Permit Number: 041323

This is to certify that Seavey Timothy E / Green Leaf Construction
has permission to Build 20' x 30' extension to the existing building.
AT 30 Washington Ave 013 F007001

Proposed Use: Commercial/ Build 24' x 28' extension to the existing building. Applied for site plan.	Proposed Project Description: Build 24' x 28' extension to the existing building.
---	---

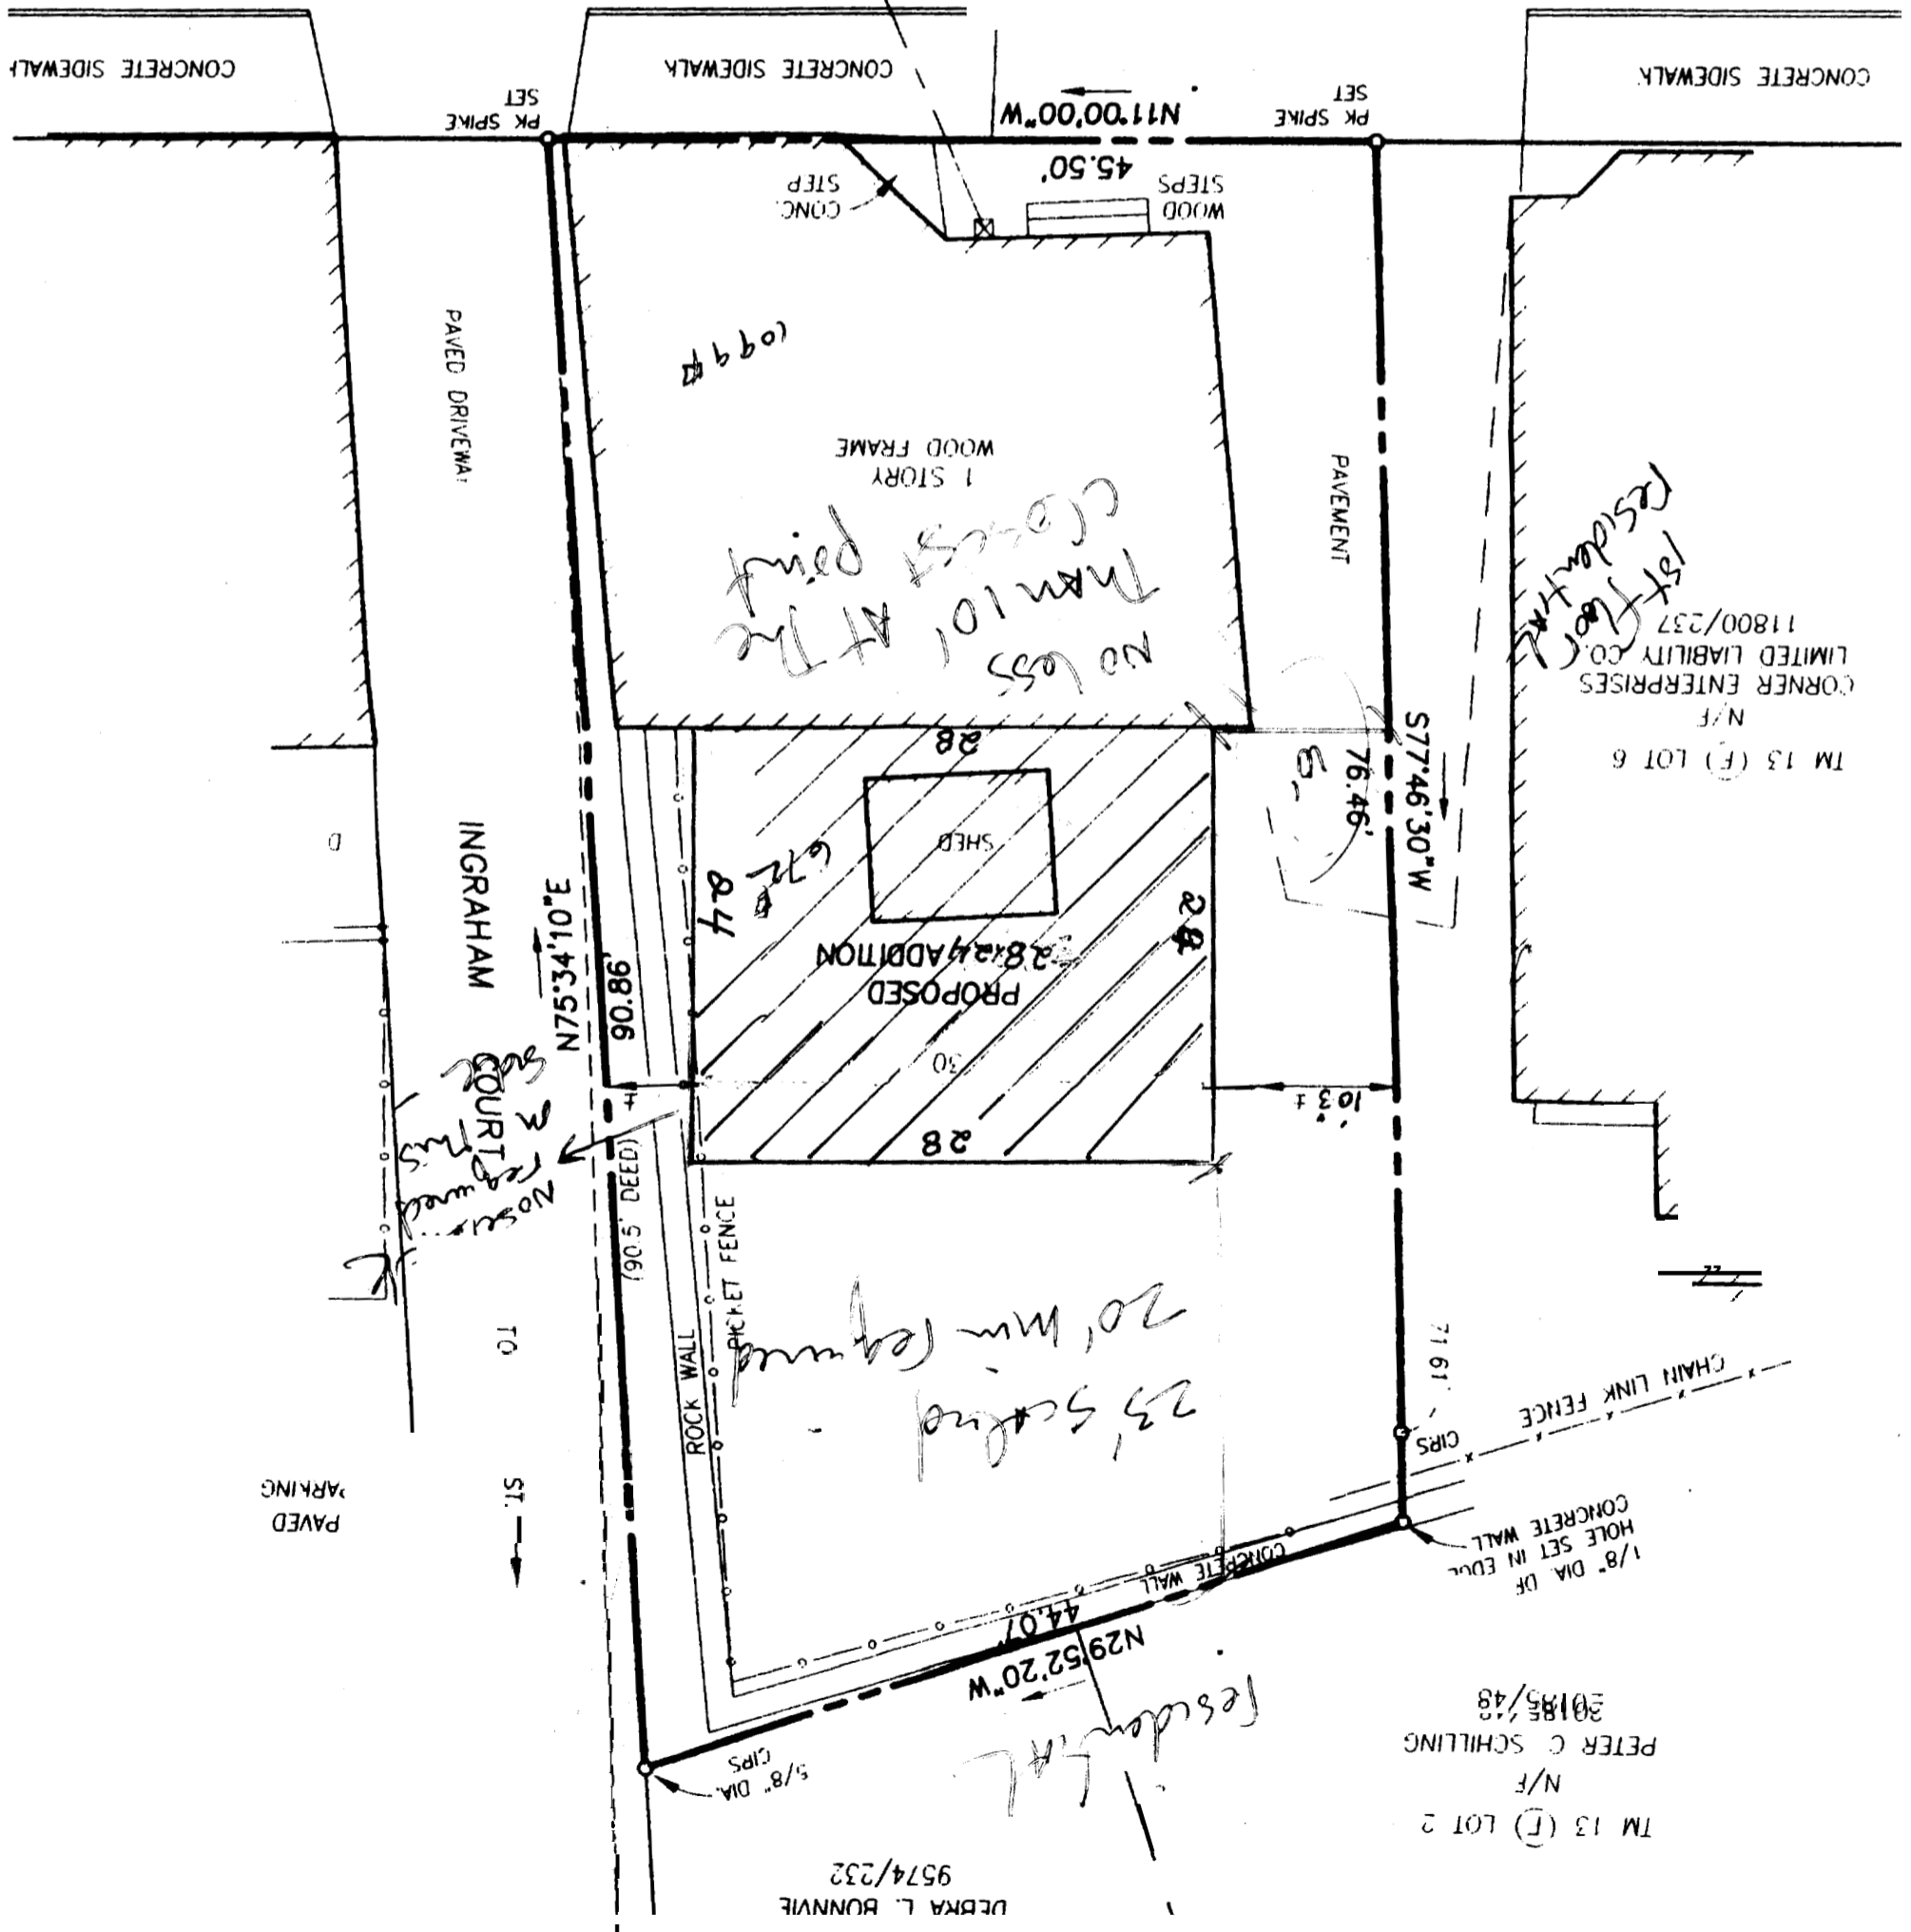
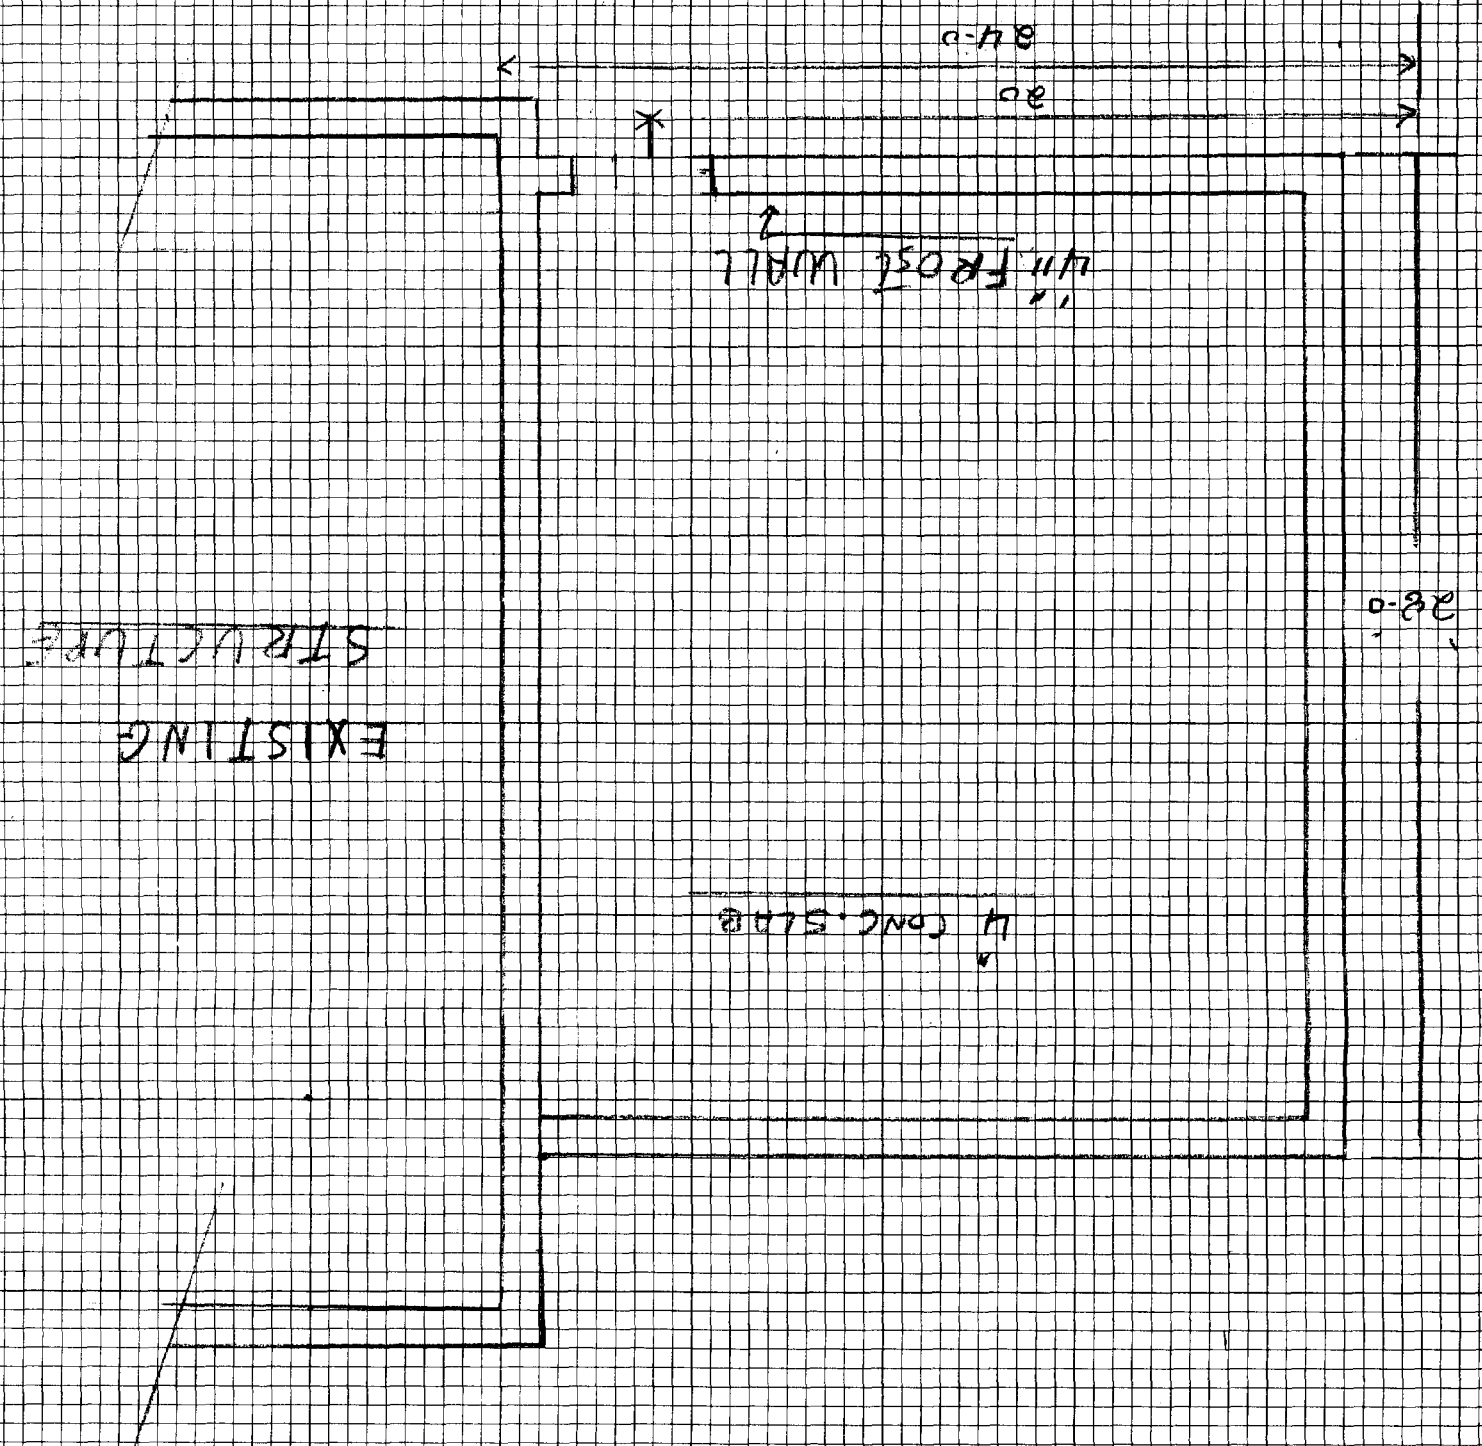
Dept: Zoning **Status:** Approved with Conditions **Reviewer:** Marge Schmuckal **Approval Date:** 09/17/2004
Note: setbacks were not being met because on the left side there is a residential unit on the first floor - 10' setback Ok to Issue:
 is required
 9/16/04 received revised plans - I brought one up to Sarah

- 1) It is understood that the closest that the left side setback shall be no closer than 10 feet to the side lot line. The Code Enforcement Officer may want a surveyor to verify the setback.
- 2) Separate permits shall be required for any new signage.
- 3) This permit is being approved on the basis of plans submitted on 9/16/04. Any deviations shall require a separate approval before starting that work.
